Rezoning Transportation Analysis
Petition Number: Insert Zoning Petition #2021-263
General Location Identifier: 15717222, 15717233

Revision Log:	Date	Revision Log:
	04-18-2022	First Review (WB)
	05-24-2022	Second Review (WB)

**RZ1-0**

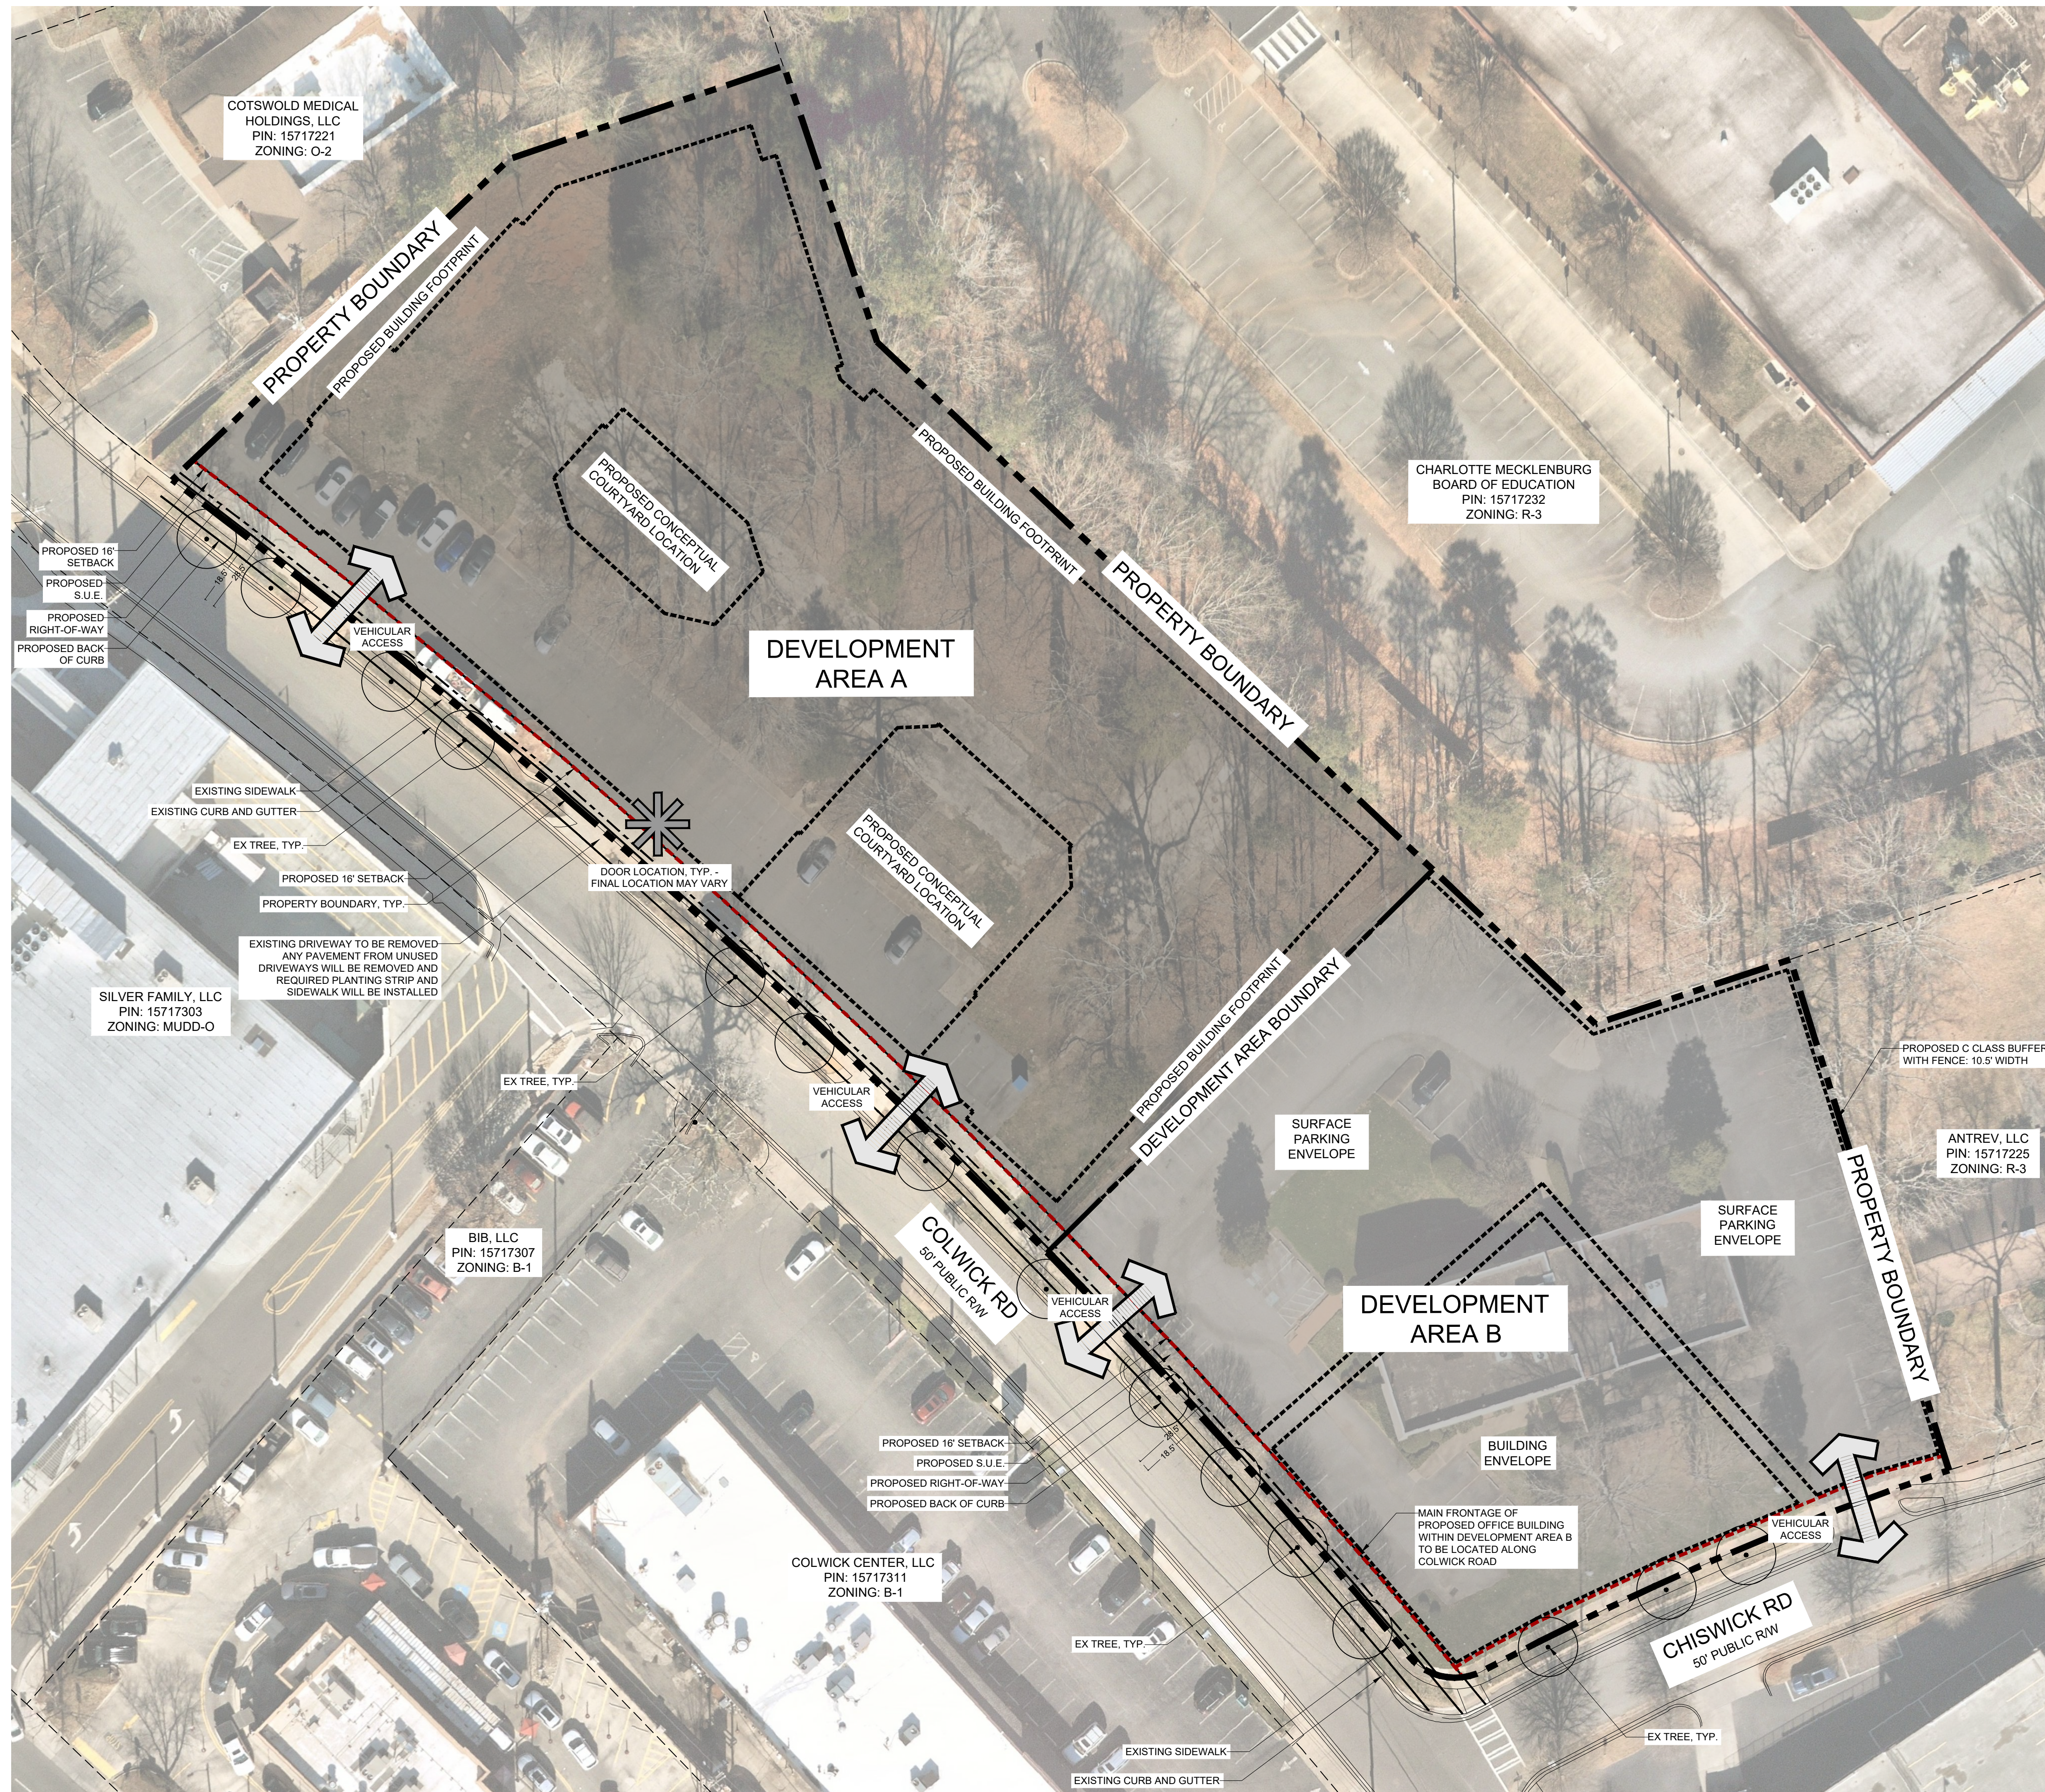
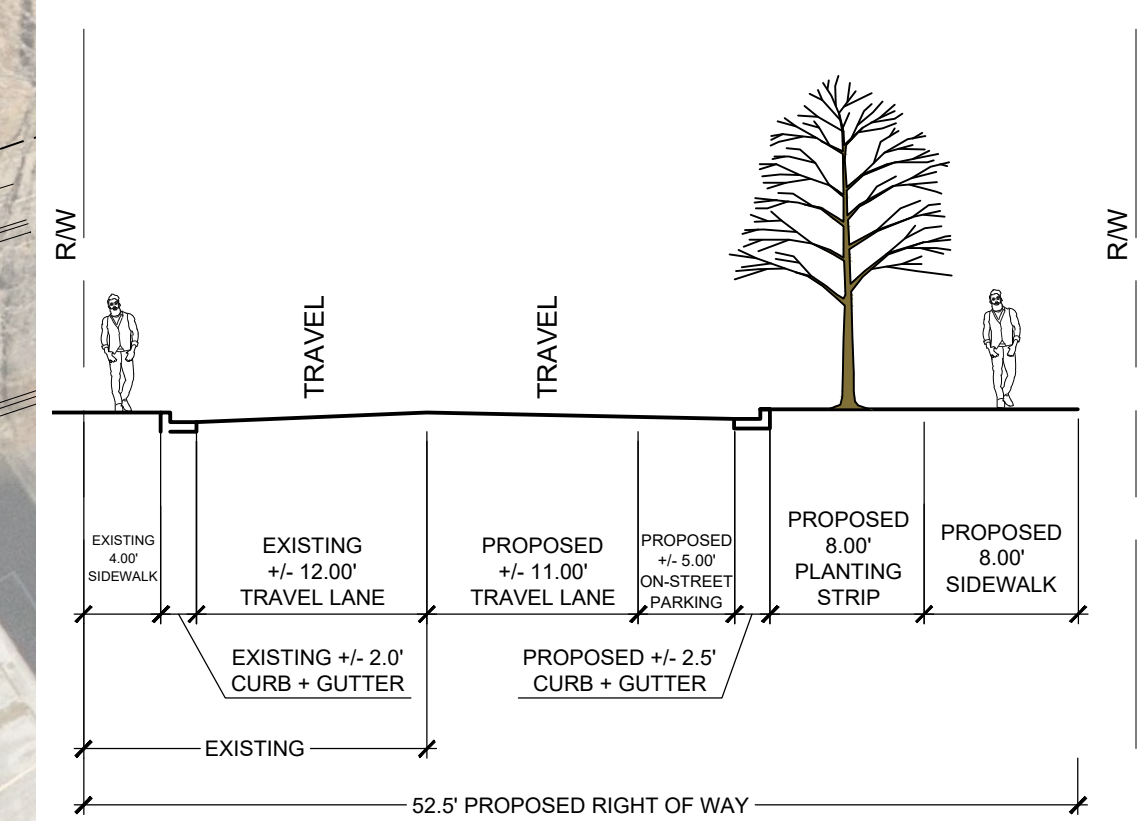
1. **Curblines:** The proposed zoning district has a setback measured from the back of the existing or proposed future curblines.
 - a. **Colwick Road:** The back of curb and gutter needs to be relocated to 20.5-feet from the road centerline.
 - b. **Chiswick Road:** The back of curb and gutter needs to be relocated to 20.5-feet from the road centerline.

Label and dimension the curb and gutter from the centerline for each road on the site plan.

Revise site plan and conditional notes to commit to reconstruct the curb and gutter 20.5-ft from the road centerline of Colwick Road ~~both Public streets~~ to provide on-street parking per the Local Commercial Wide typical section and Chapter 20 of the City's ordinance. Curb and gutter comment rescinded for Chiswick Road as the offset between the driveway and intersection limits the spacings for on-street parking. The site plan shall label and dimension the proposed back of curb and gutter from the Colwick Road centerline.

Revise site plan and conditional notes to commit to construct an 8-foot planting strip, and 8-foot sidewalk on Chiswick Road per CLDSM U-05A. The site plan shall label and dimension both items from the back of curb and gutter and road centerline. The wider sidewalk also meets the Charlotte WALKS Policy.
